ZONING BOARD OF APPEALS

October 26, 1988

This is in reference to your recent application for a three car garage to be constructed at 19 Abbott Street in Portland. The side and rear yard setbacks for the proposed garage do not comply with the setbacks which were adopted by the Portland City Council on July 19, 1988, a copy of the R-5 Zone is enclosed.

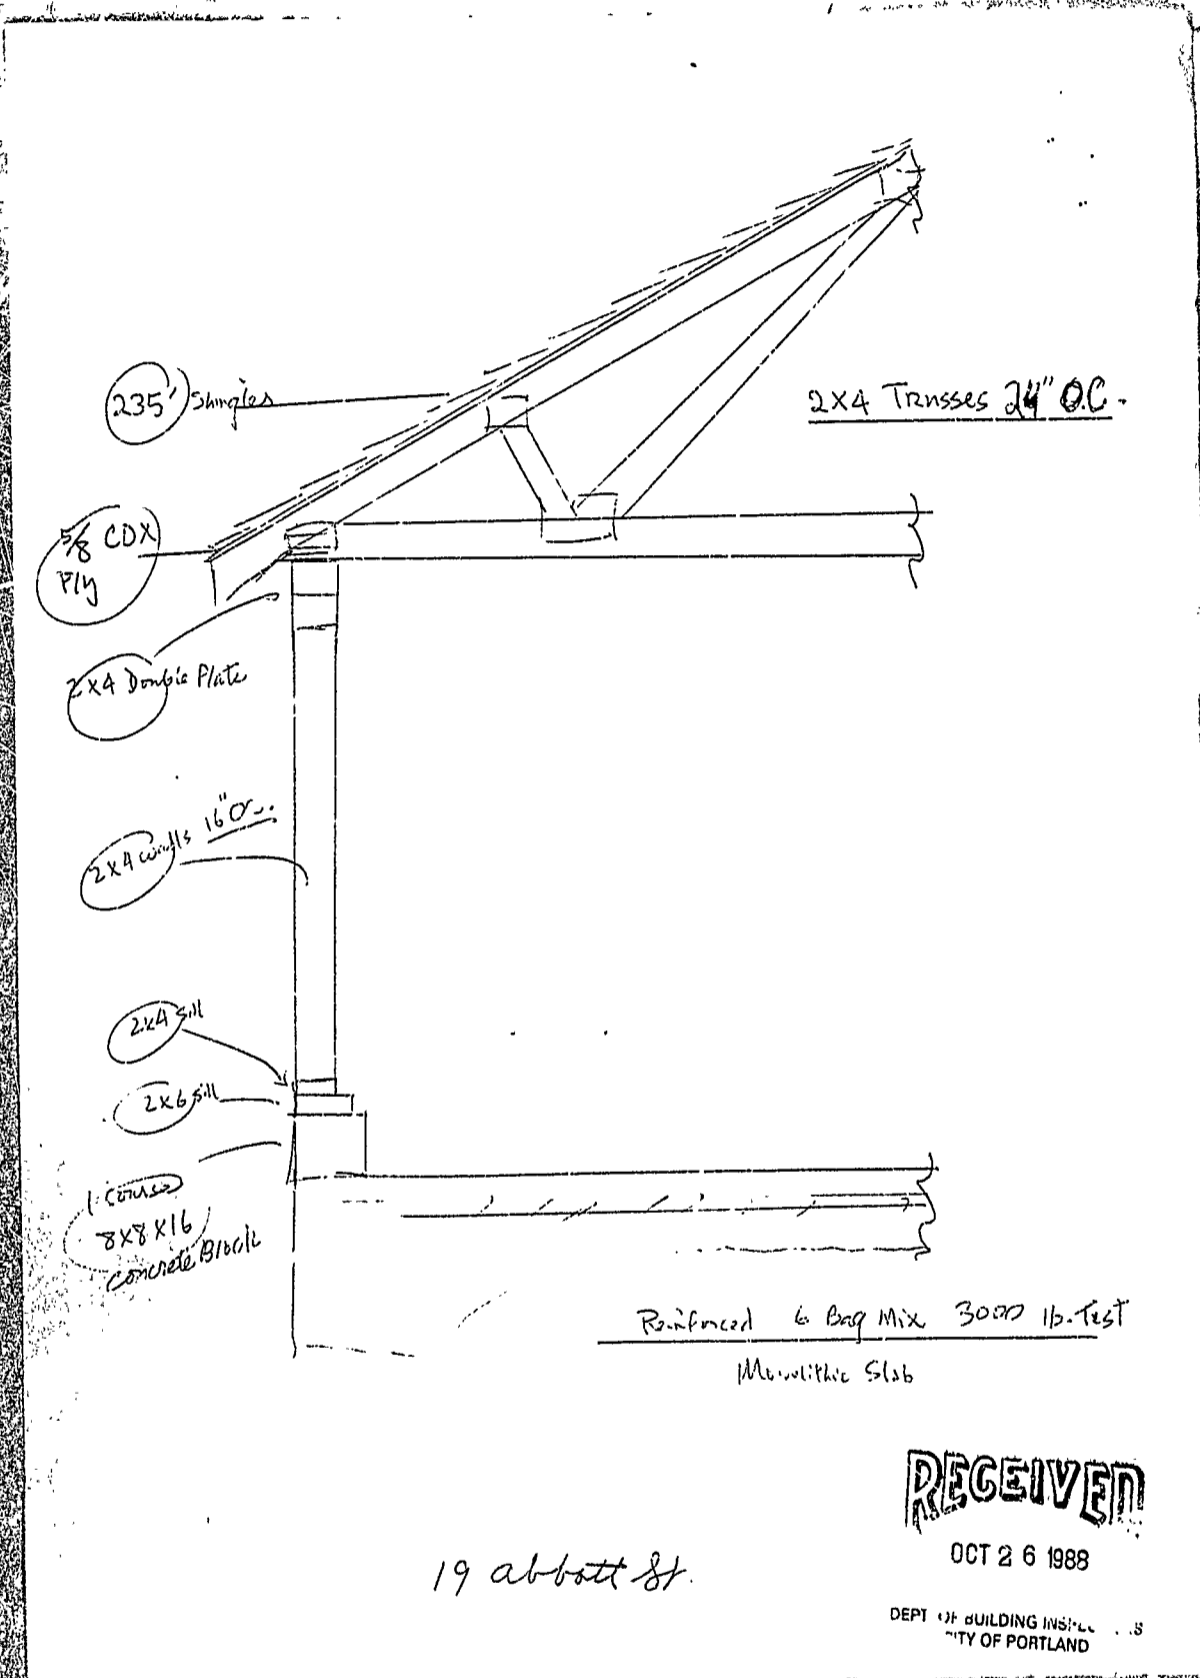
You will find in the enclosed new text for the R-5 Zone that there are now new setbacks which apply to this proposed project:

Front yard: 20 feet
Rear yard: 20 feet
Side yard: 12 feet (for a two story main building)

These new front, side and rear yard setbacks do not reflect those which your plot plan shows. Therefore a redesign of the plot plan or a request for a variance before the Board of Appeals would be appropriate choices for the owner of this property to consider as alternatives.
